WRITTEN REPRESENTATION

**TO: INSPECTORS RE SPR DCO APPLICATIONS FOR
WINDFARMS EAIN AND EA2**

My reference EA1N 20023282 / EA2 20023287

Figure: 8g
CHVP3: PROW between Moor Farm and Little Moor Farm

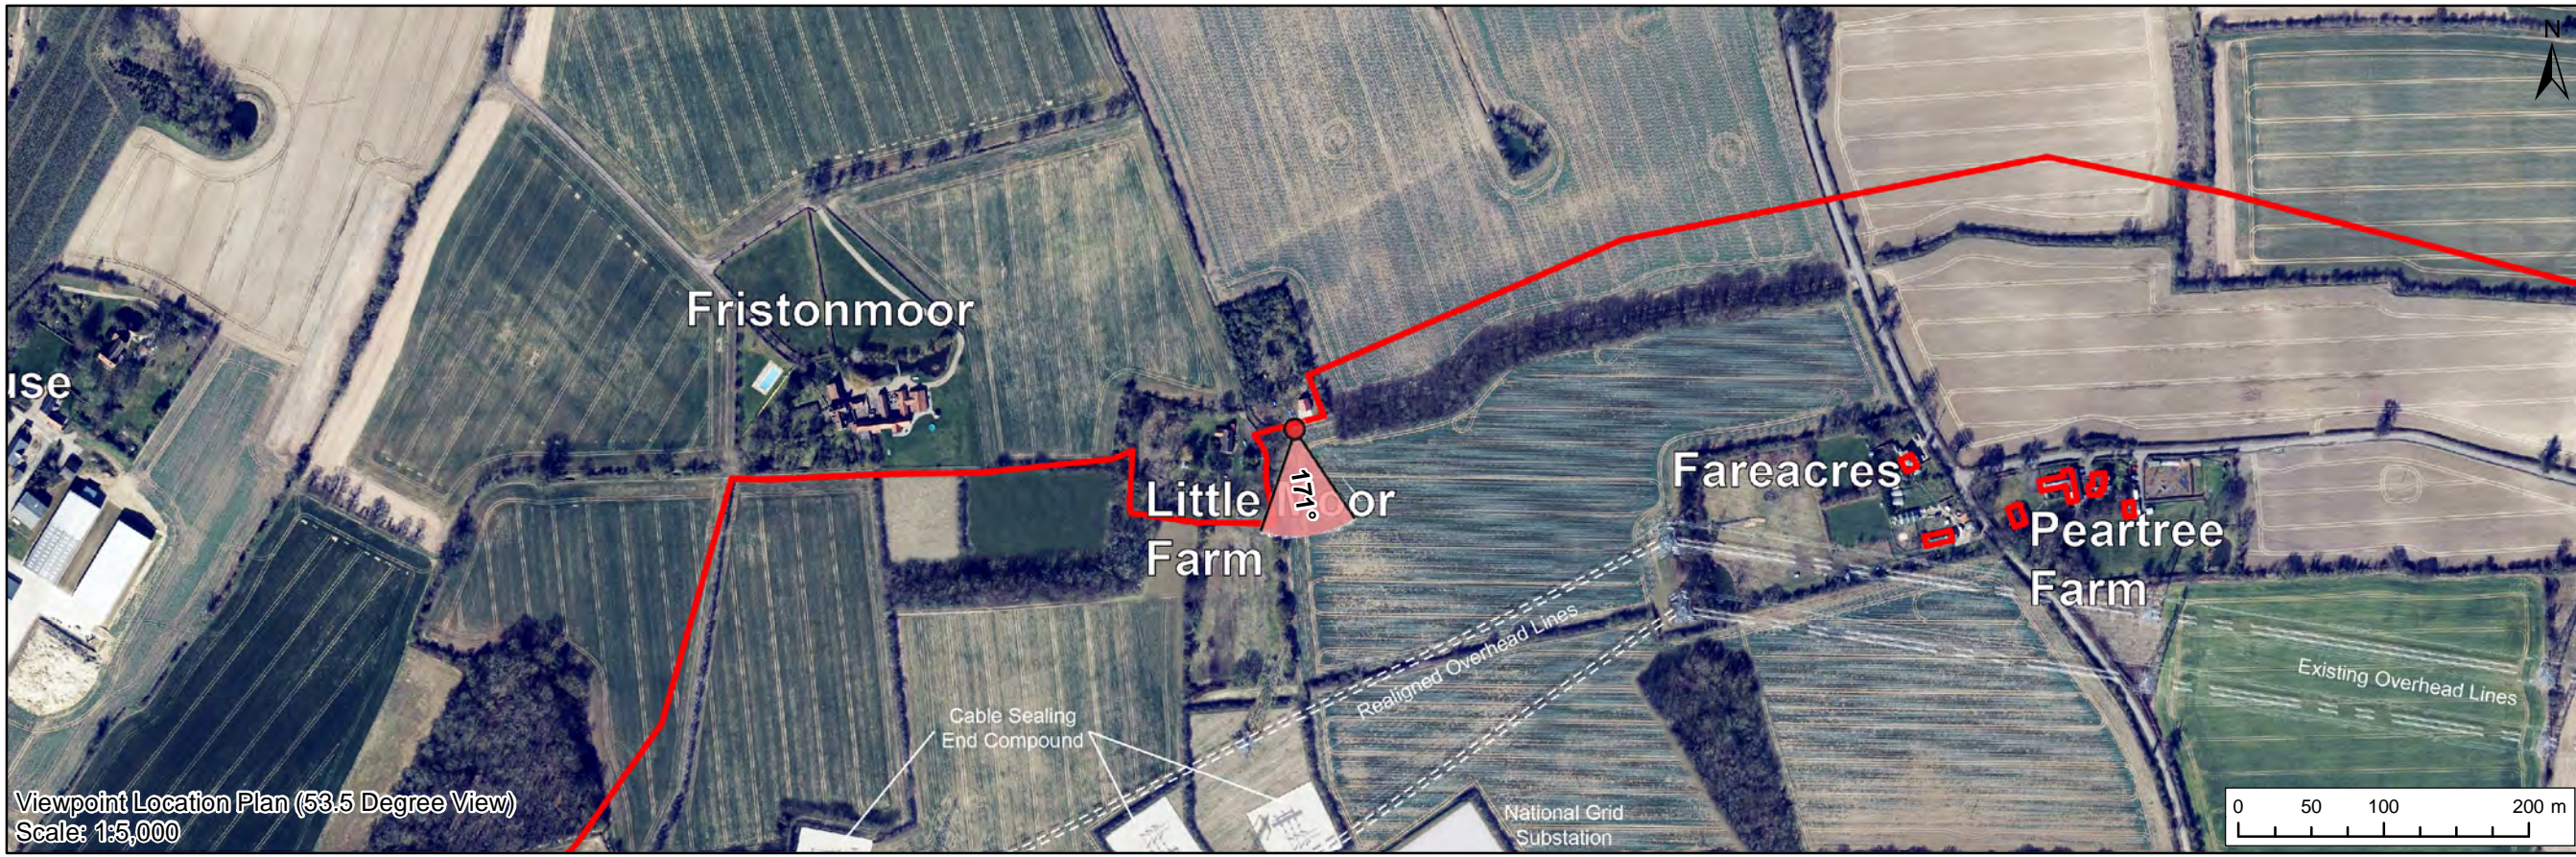
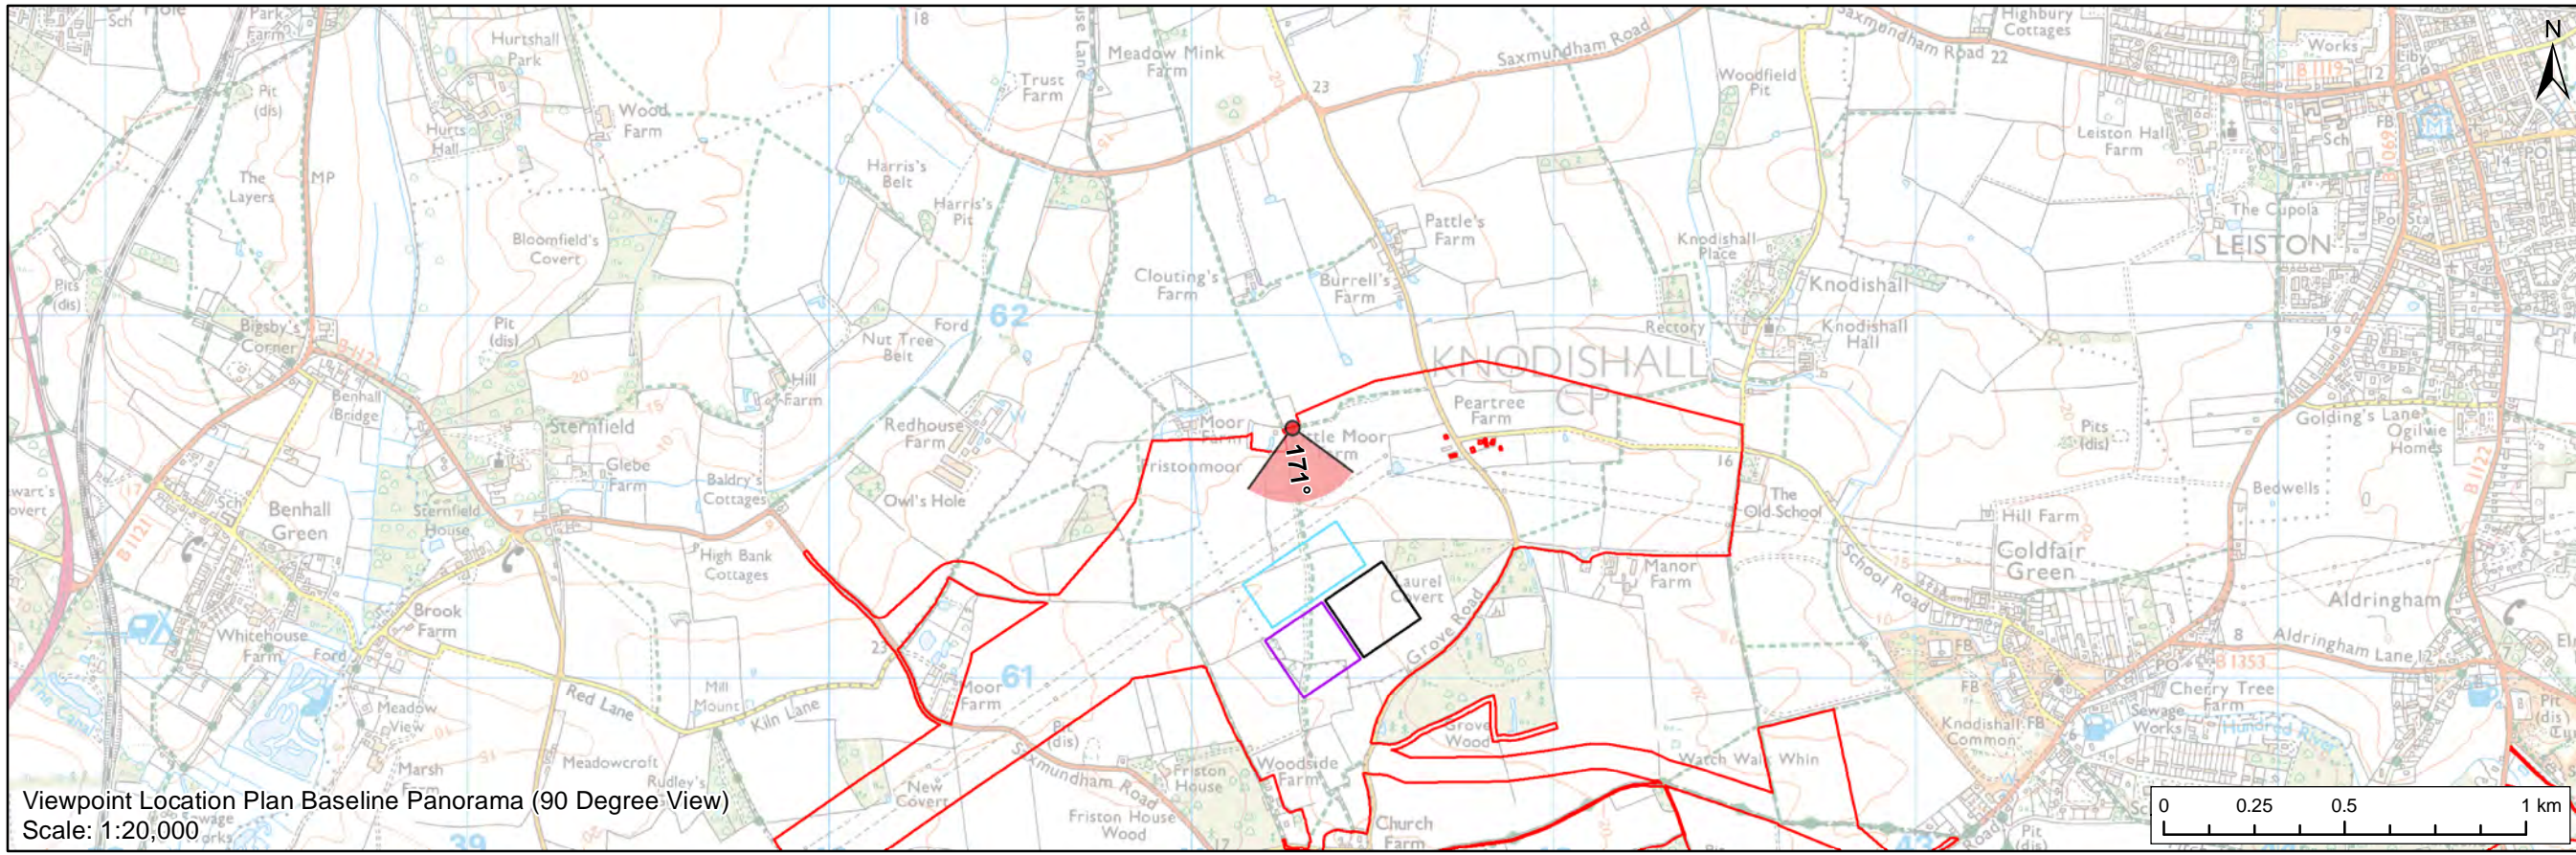
24. The SPR application misleadingly assesses the impact on [REDACTED] in the LVIA and in the Archaeological and Heritage assessments of the Environmental Statement. It is said that the impact of the construction and the substation will have a minimal impact on the setting and heritage value of [REDACTED].
25. In App 24.7 various assessments are set out. These rely upon two different viewpoints; one which is LVIA VP5 and which is CH VP3.

26. Neither of these viewpoints show the view from the actual house to the village. See attached Drone photo below annotated to show the viewpoints SPR use for their assessment.. This seems to have been taken deliberately from the most irrelevant vantage points that could possibly be chosen. This is characteristic of the approach taken in the application as a whole. These vantage points have self-evidently been selected to support the misleading conclusion that the overall impact is minimal.

Figure: 29.37e
Viewpoint 5: Public Right of Way, near Moor Farm

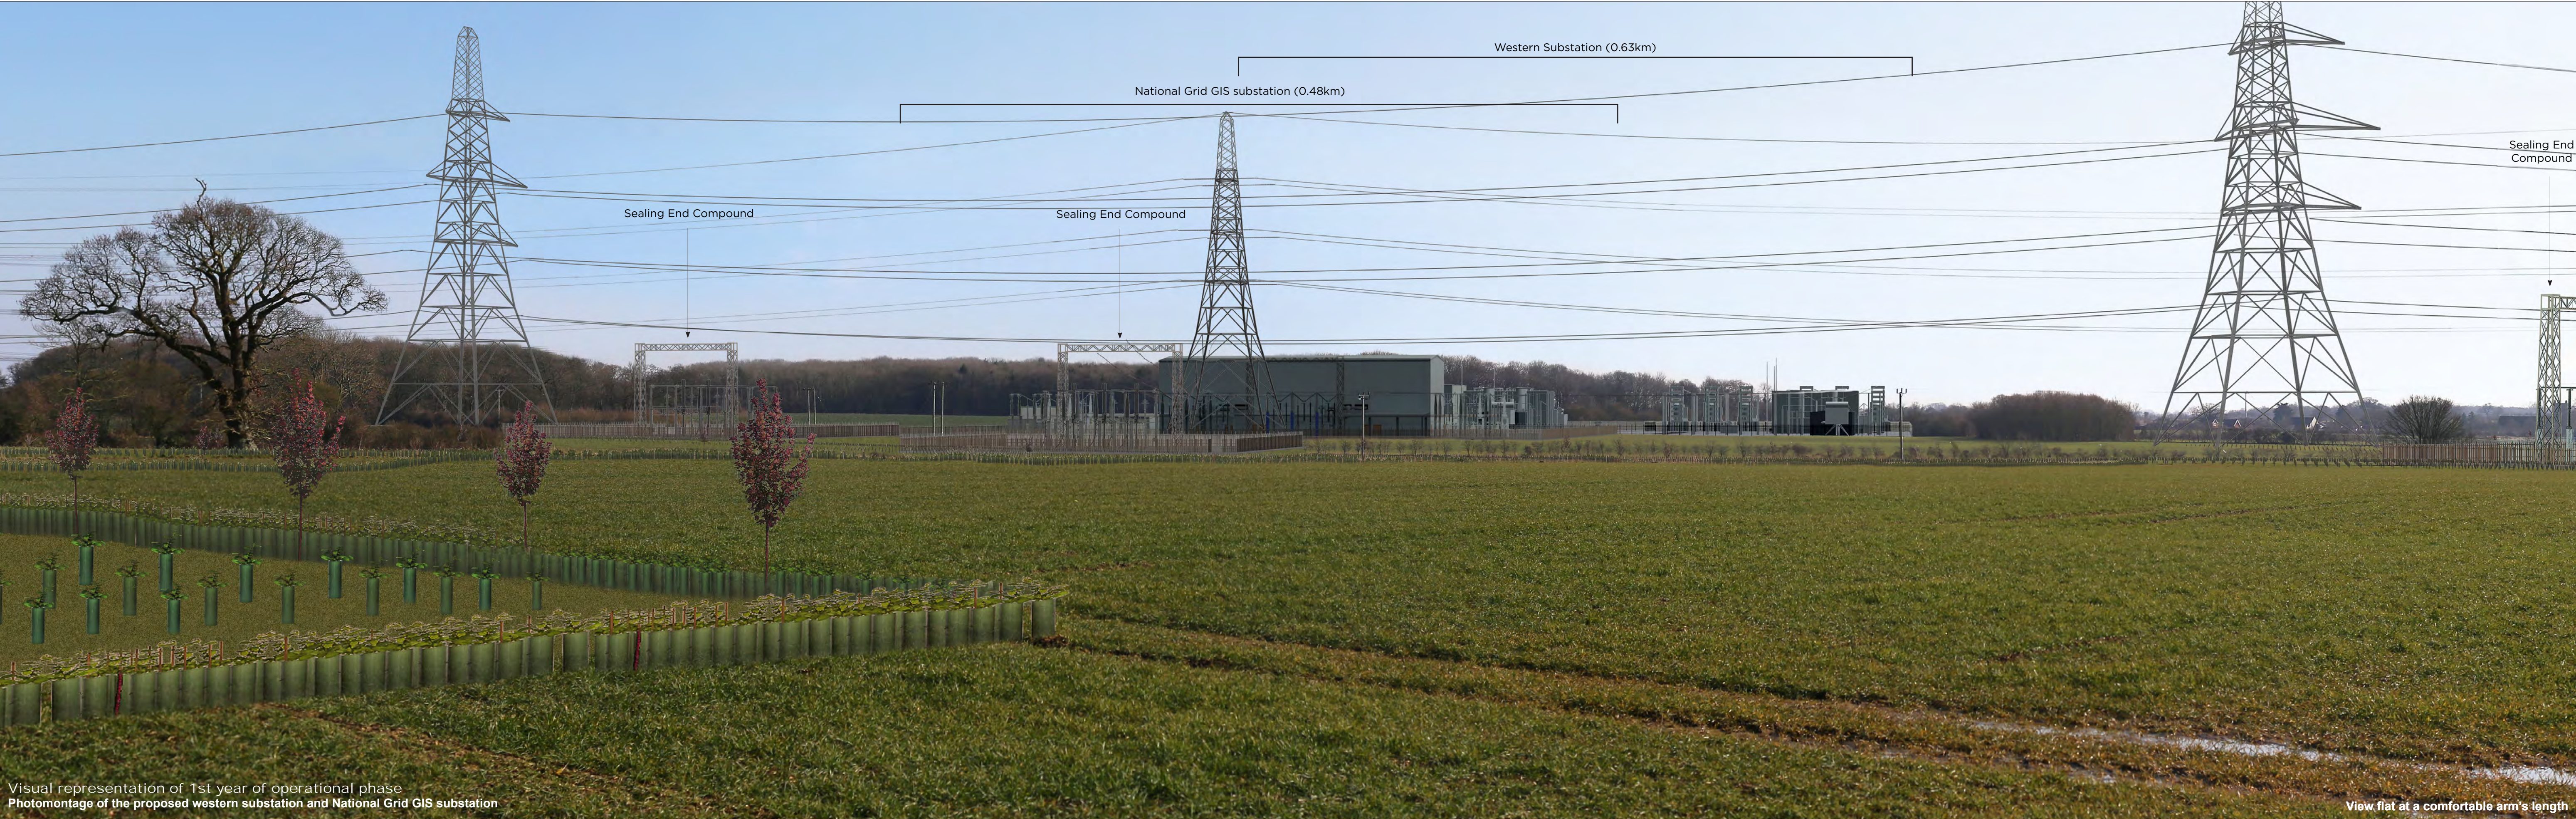
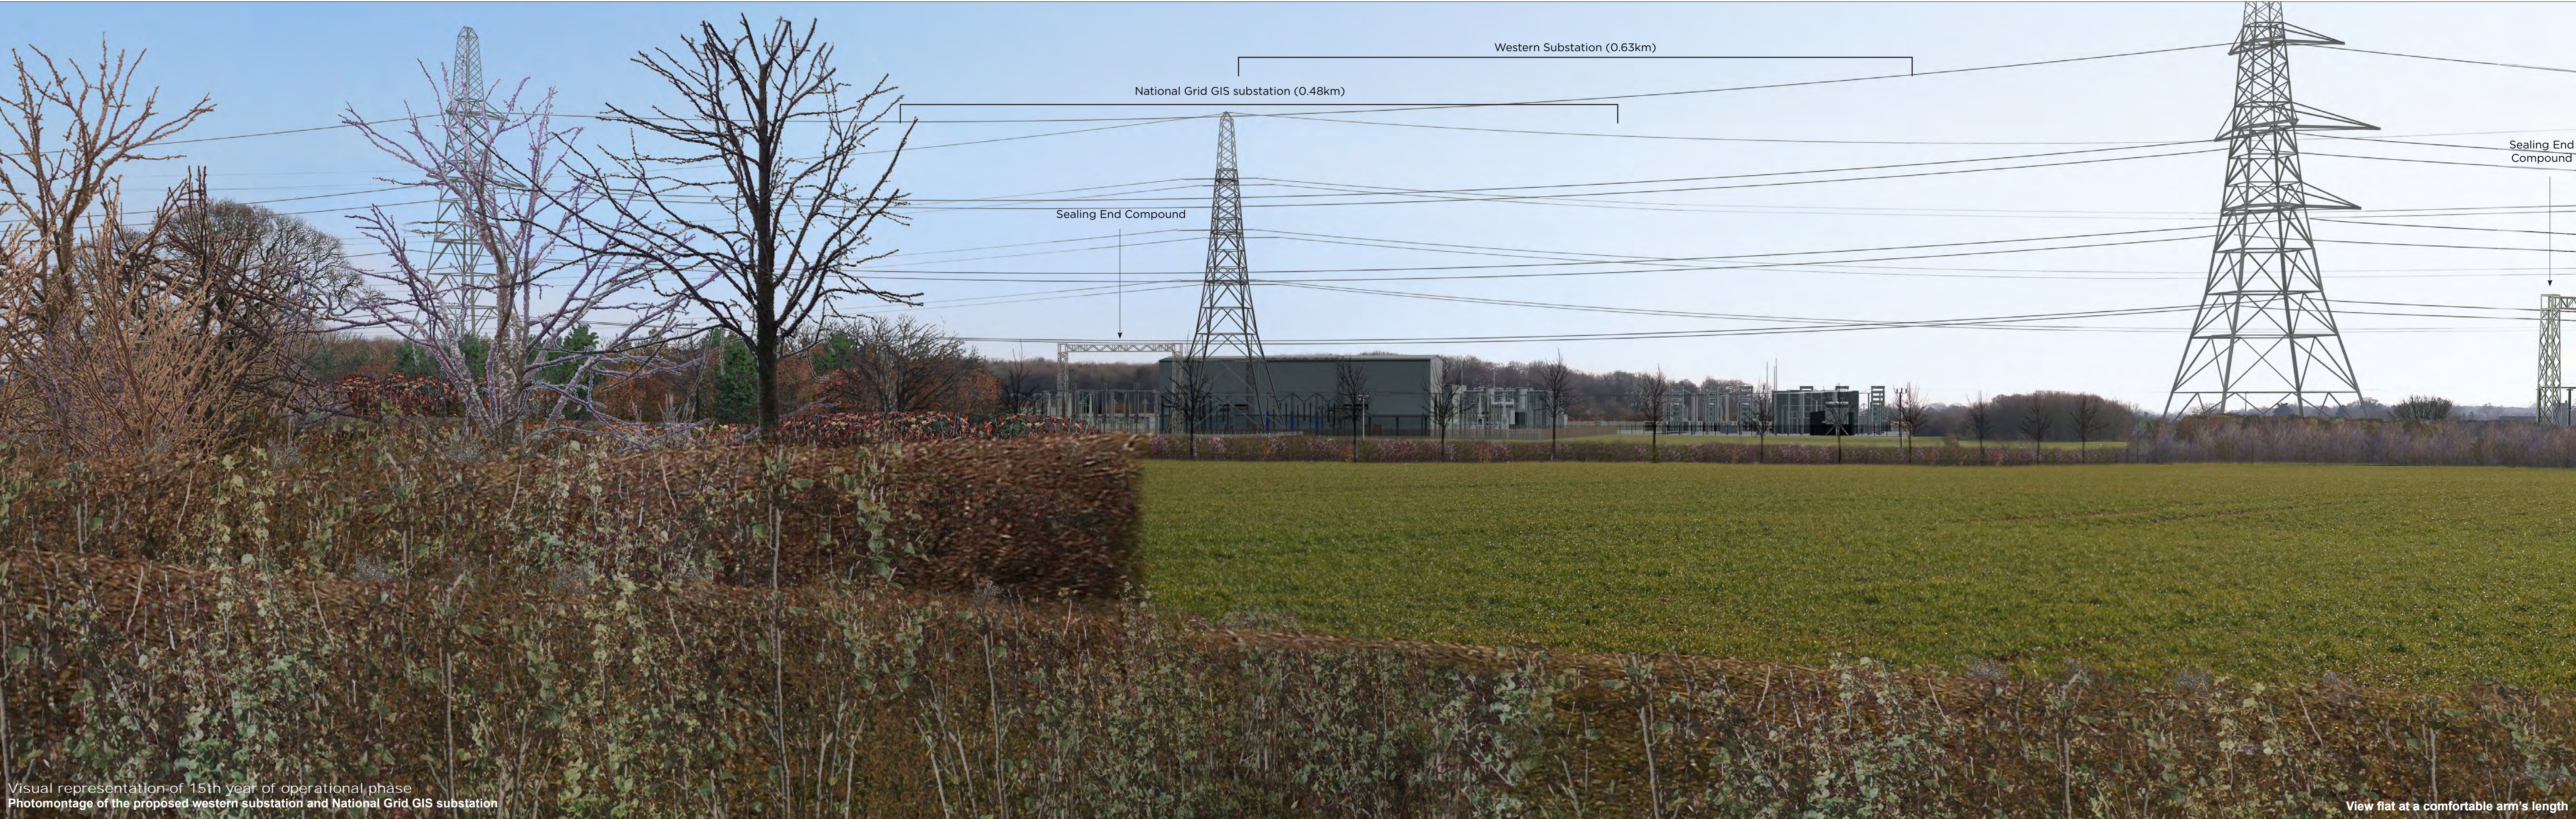
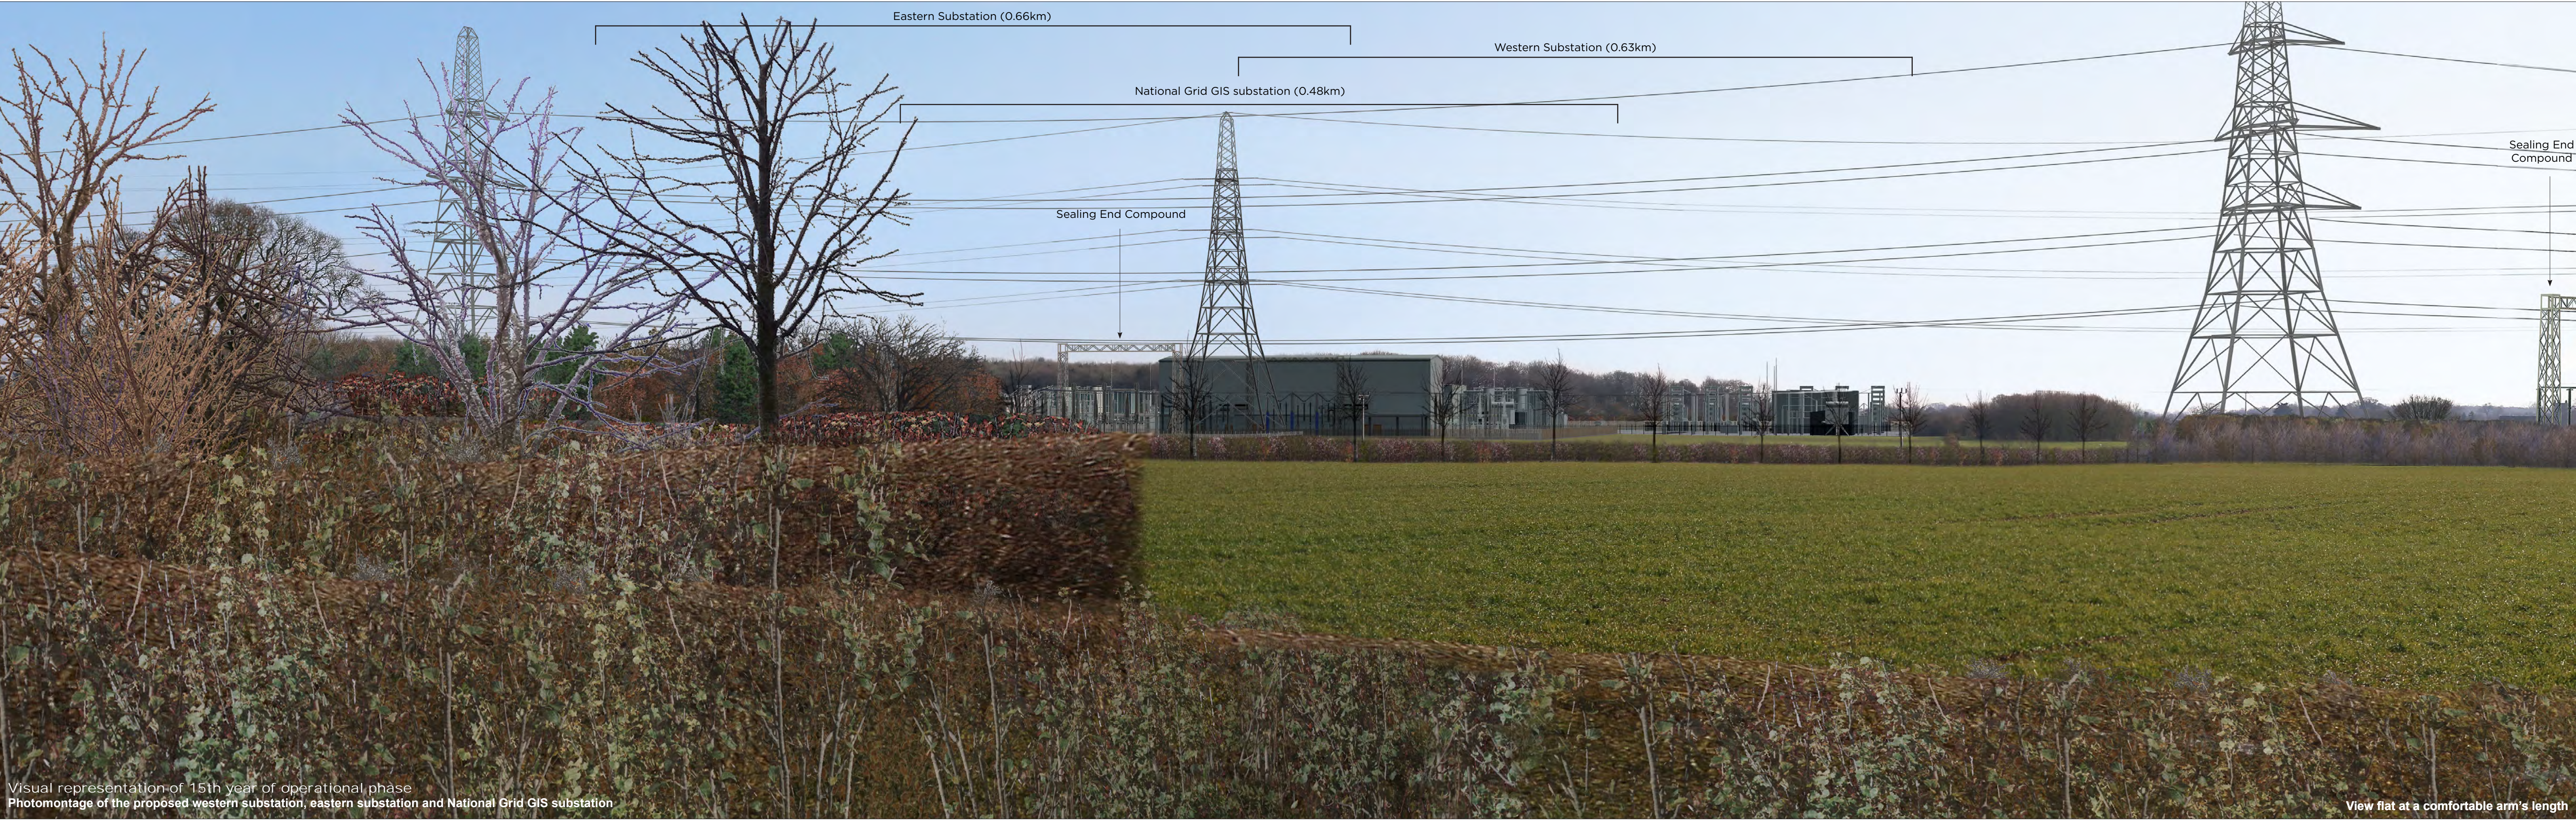
36. Indeed, in the 15-year post construction visualisation prepared by SPR the substation is still visible, even from the unrepresentative visualisation viewpoints chosen by SPR to be reflective of the impact on [REDACTED]. As matters stand SPR is not even planning to adequate screening to the [REDACTED].
